**WELWYN HATFIELD BOROUGH COUNCIL  
EXECUTIVE DIRECTOR - PLANNING, PUBLIC PROTECTION AND GOVERNANCE**

**DELEGATED APPLICATION**

**Application No:** 6/2018/0383/FULL  
**Location:** 8 Hill Rise Cuffley Potters Bar EN6 4EE  
**Proposal:** Erection of a three storey detached house with a raised patio following demolition of existing dwelling  
**Officer:** Mr David Elmore

Project Address	8 Hill Rise, Potters Bar, EN6 4EE
Sheet Title	Proposed Elevations
Sheet Number	A107
Paper Size	A1
Revision	E
Issue Date	29/01/2018

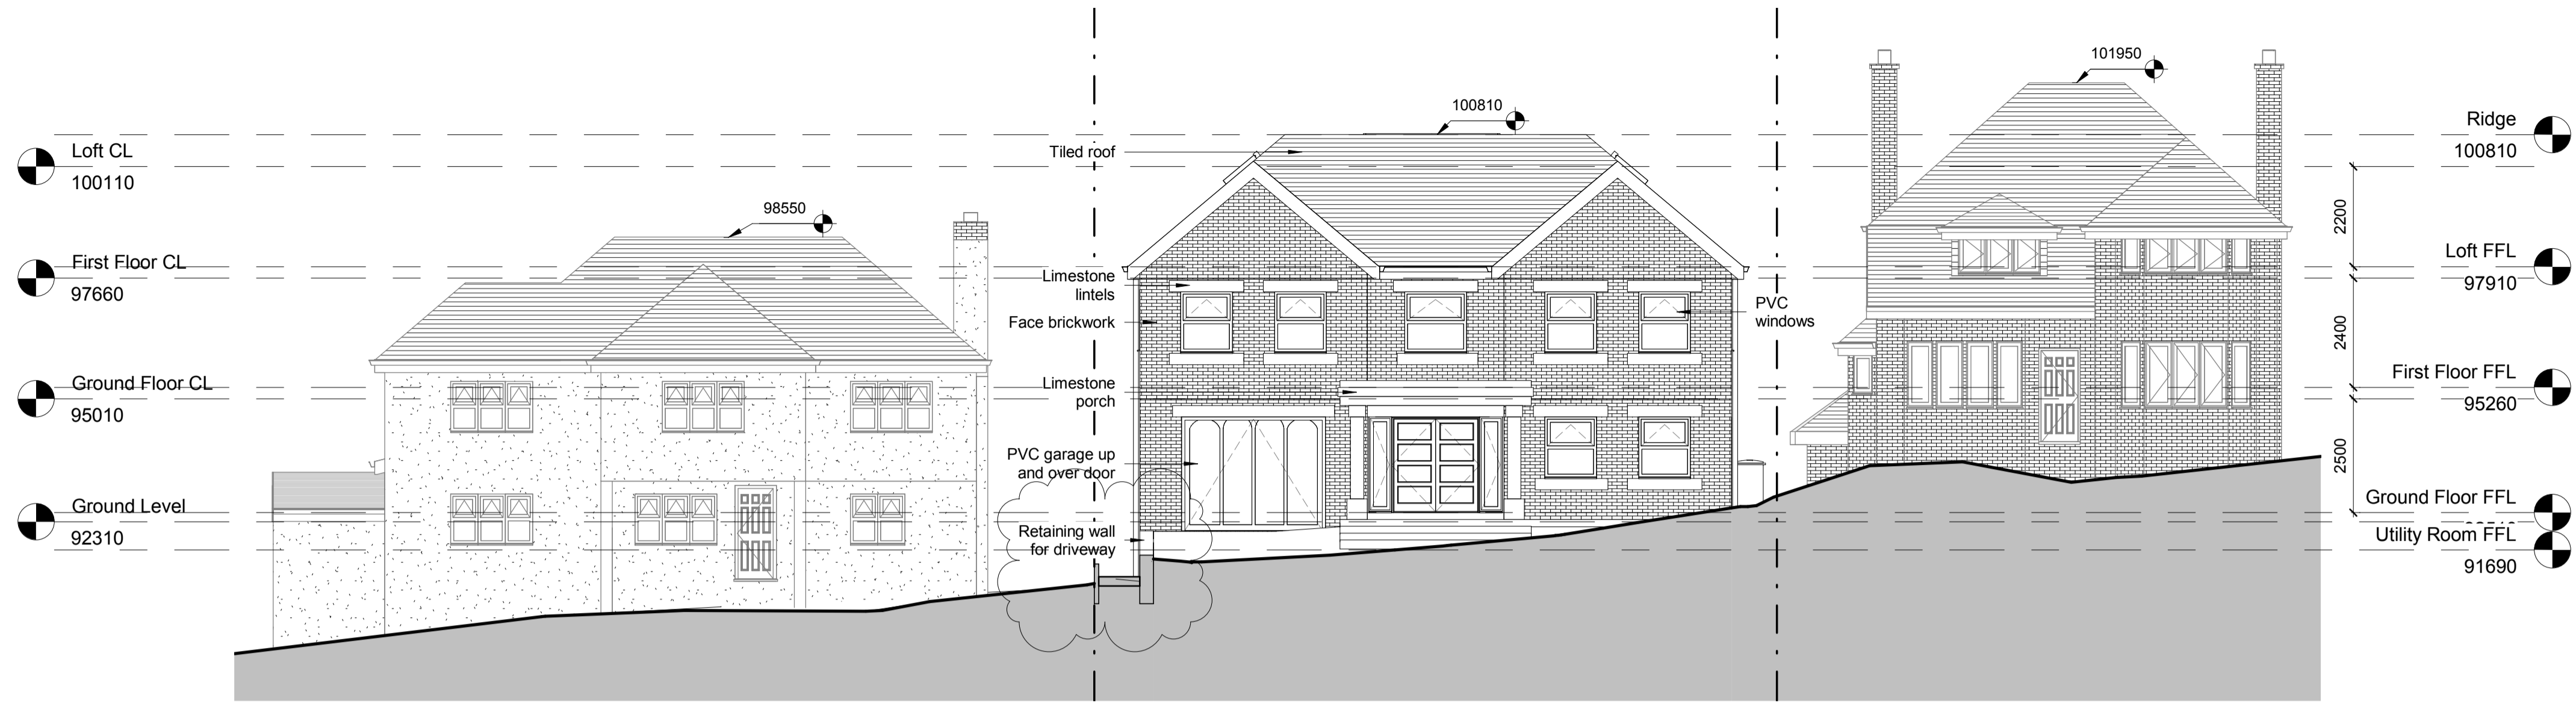
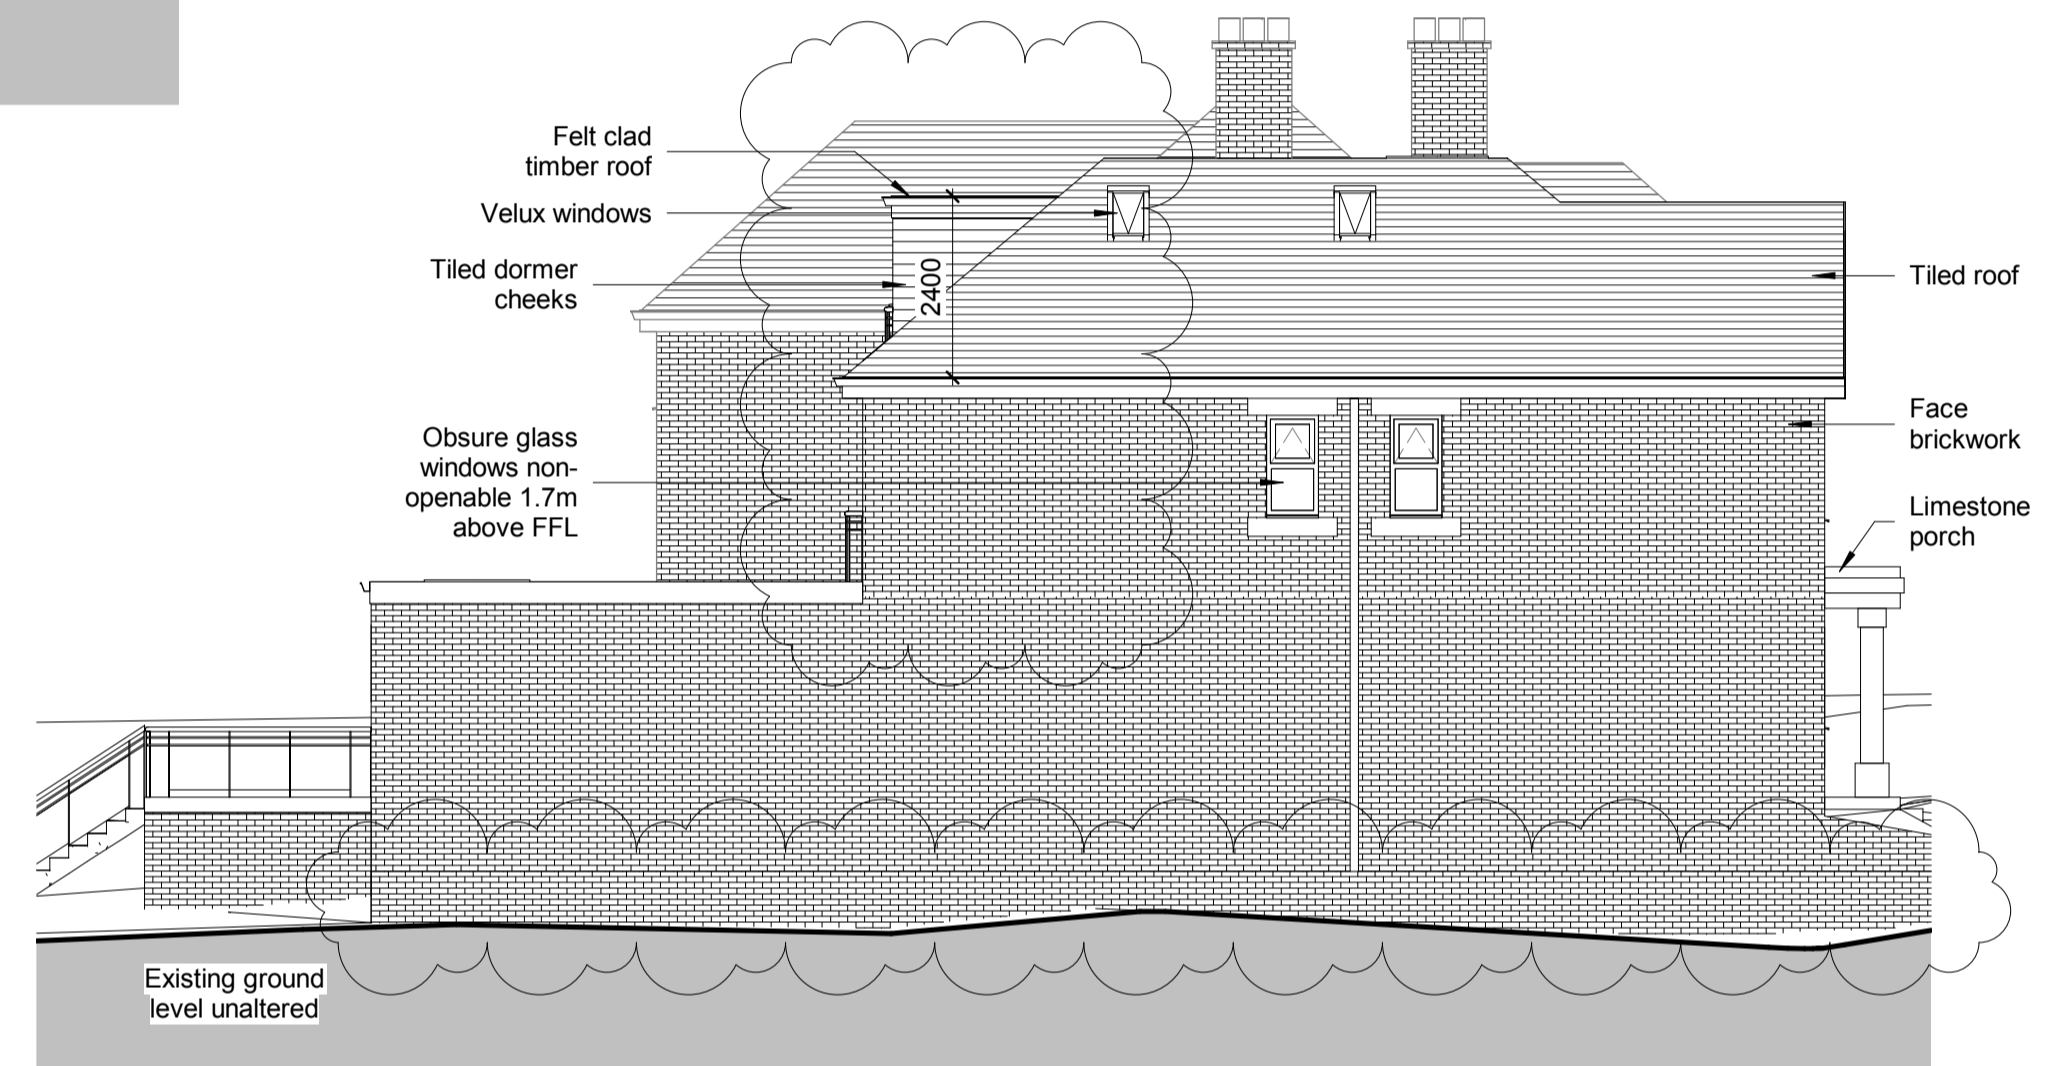
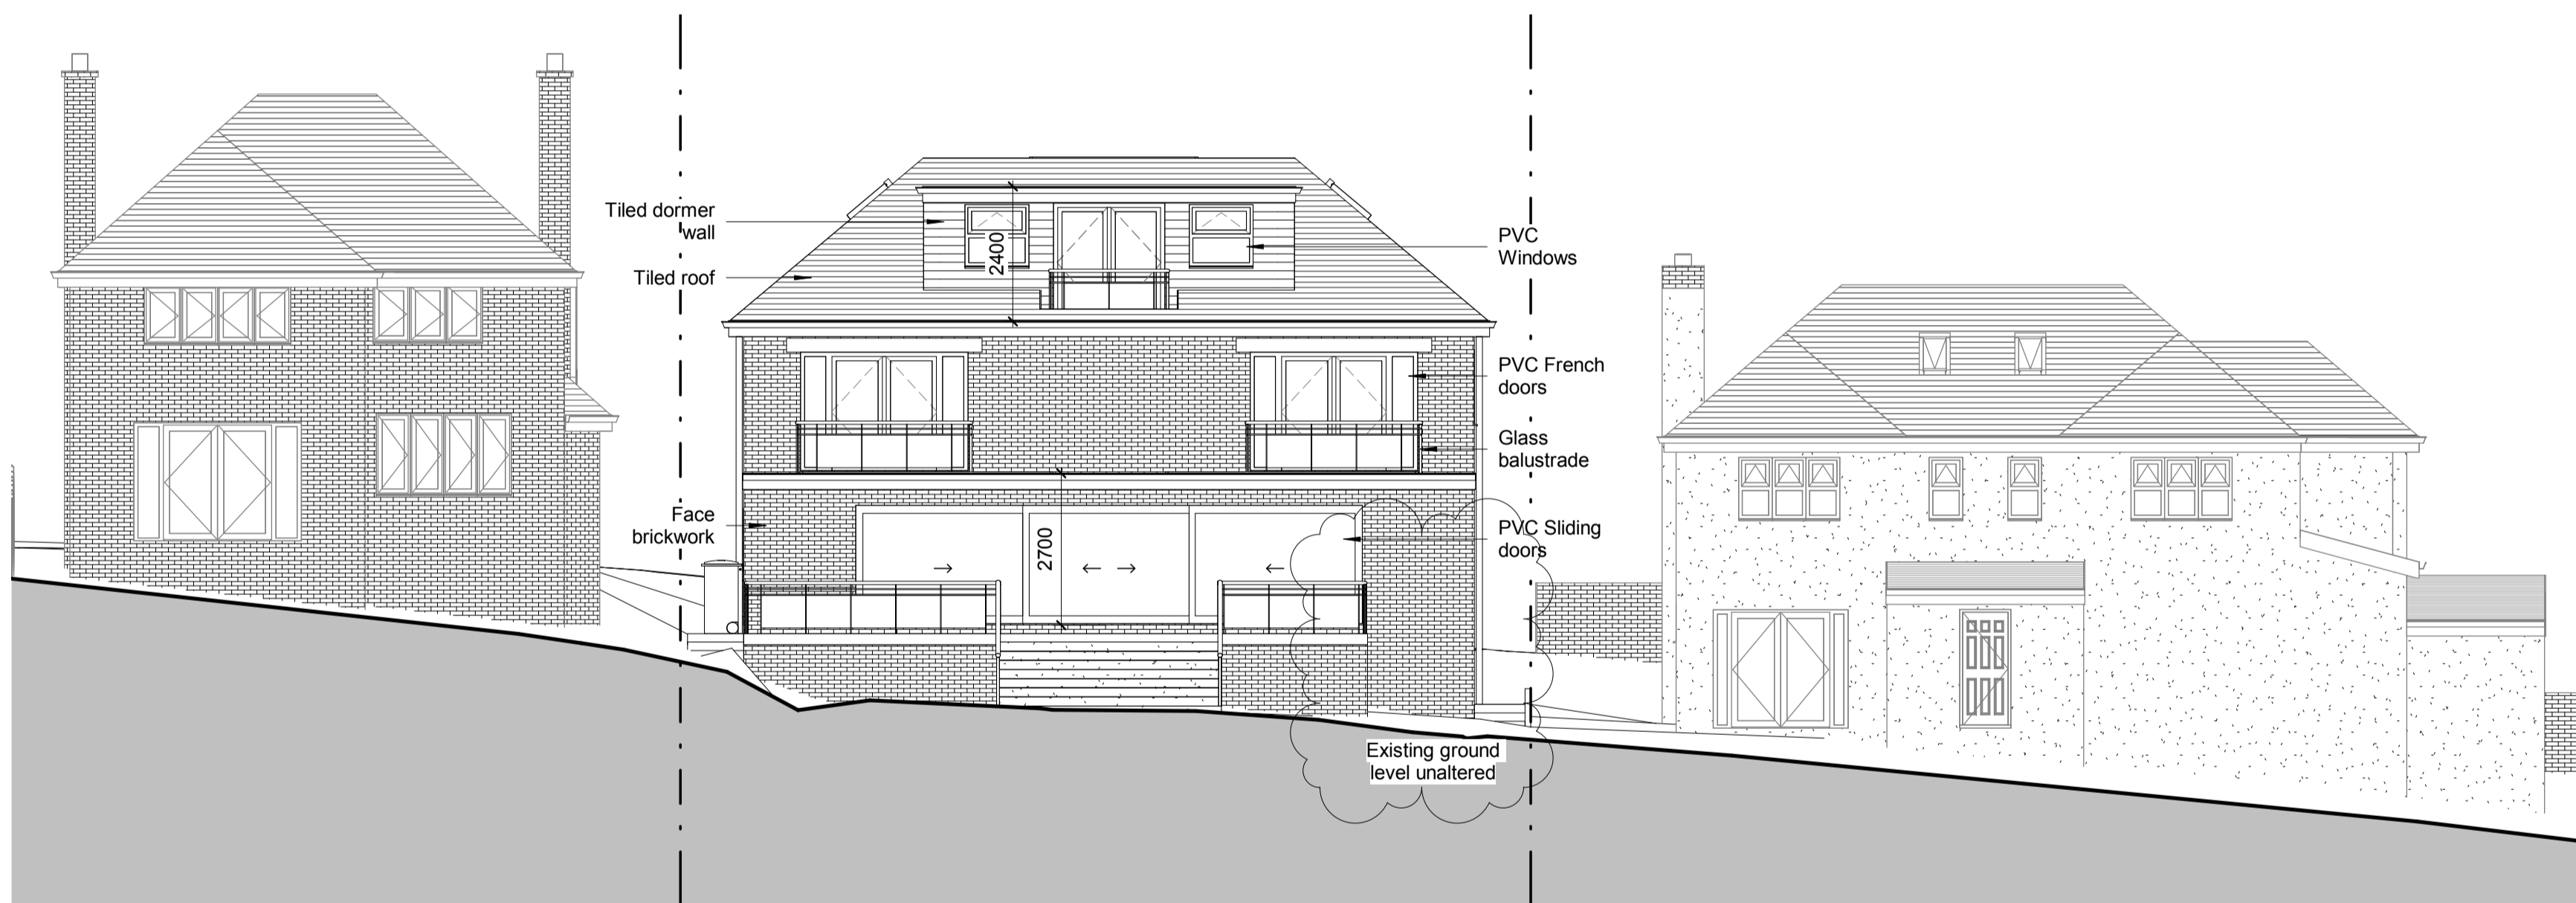
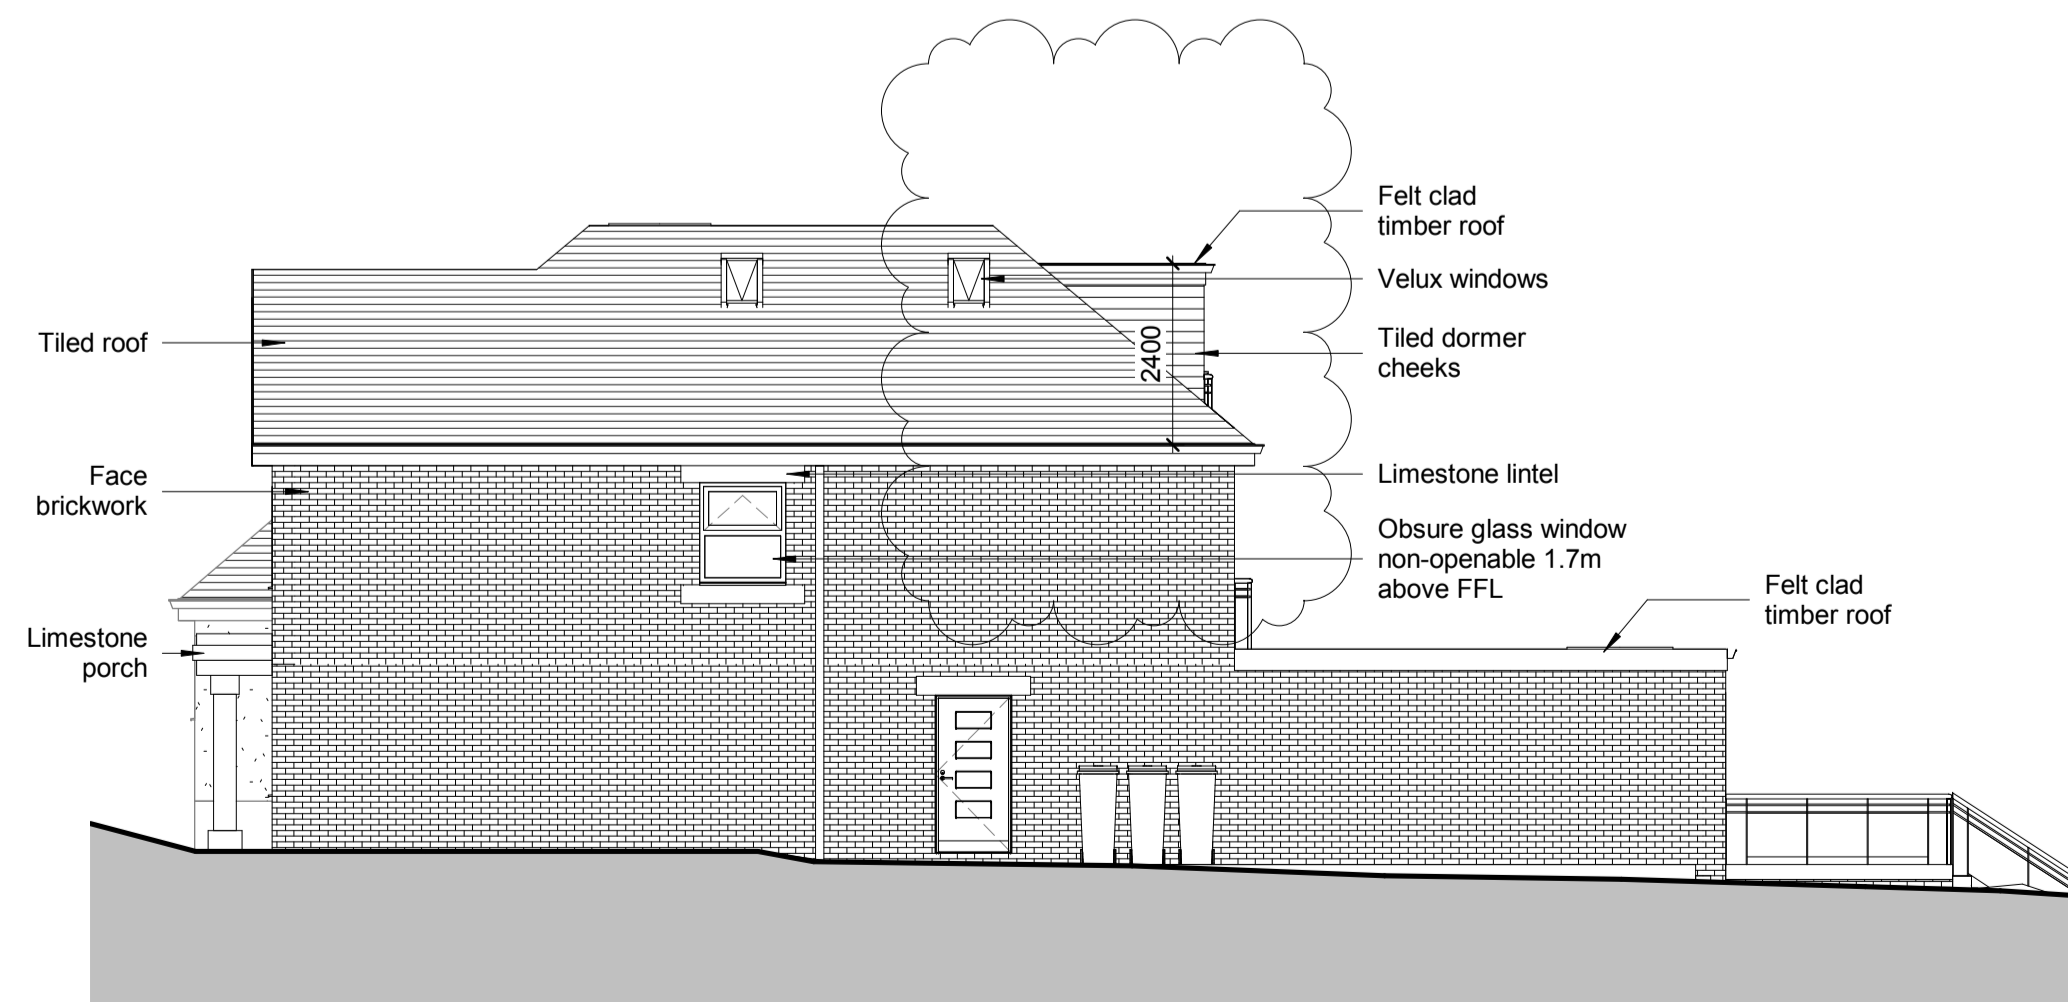
A first floor side window (serving a bathroom) and 2no side roof lights (serving a bedroom) would face this property. The first floor side window is annotated to be glazed in obscure glass and non-openable 1.7m above finished floor level. This is necessary in the interest of protecting existing levels of privacy and can be secured through a planning condition. The proposed 2no side roof light are positioned high in the roof slope and would not present any adverse overlooking or privacy concerns from this room toward No. 6.

In terms of privacy, 2no first floor side windows (serving bathrooms) and 2no side roof lights (serving a bedroom) would face this property. It is considered necessary and reasonable for the bathrooms windows to be glazed in obscure glass and non-openable 1.7m above finished floor level. This can be secured through a planning condition. In terms of the roof lights, these are positioned high in the roof slope and would not present any adverse overlooking or privacy concerns from this room toward No. 10.

Having regard to the notable fall in land level from the application site to No. 10, consideration is also given to the potential for overlooking from the side passageway running parallel to the shared boundary with No.10. The proposed elevations and site level details clearly illustrate and annotate that the existing ground level of this side passageway would remain unaltered. This ensures that there would not be any adverse overlooking or privacy concerns toward No. 10 from any point of this passageway.

6. Any upper floor window located in a wall forming a side elevation of the building hereby approved must be obscure-glazed and non-opening unless the parts of the window which can be opened are more than 1.7 metres above the floor of the room in which the window is installed, and shall be retained in that form thereafter.
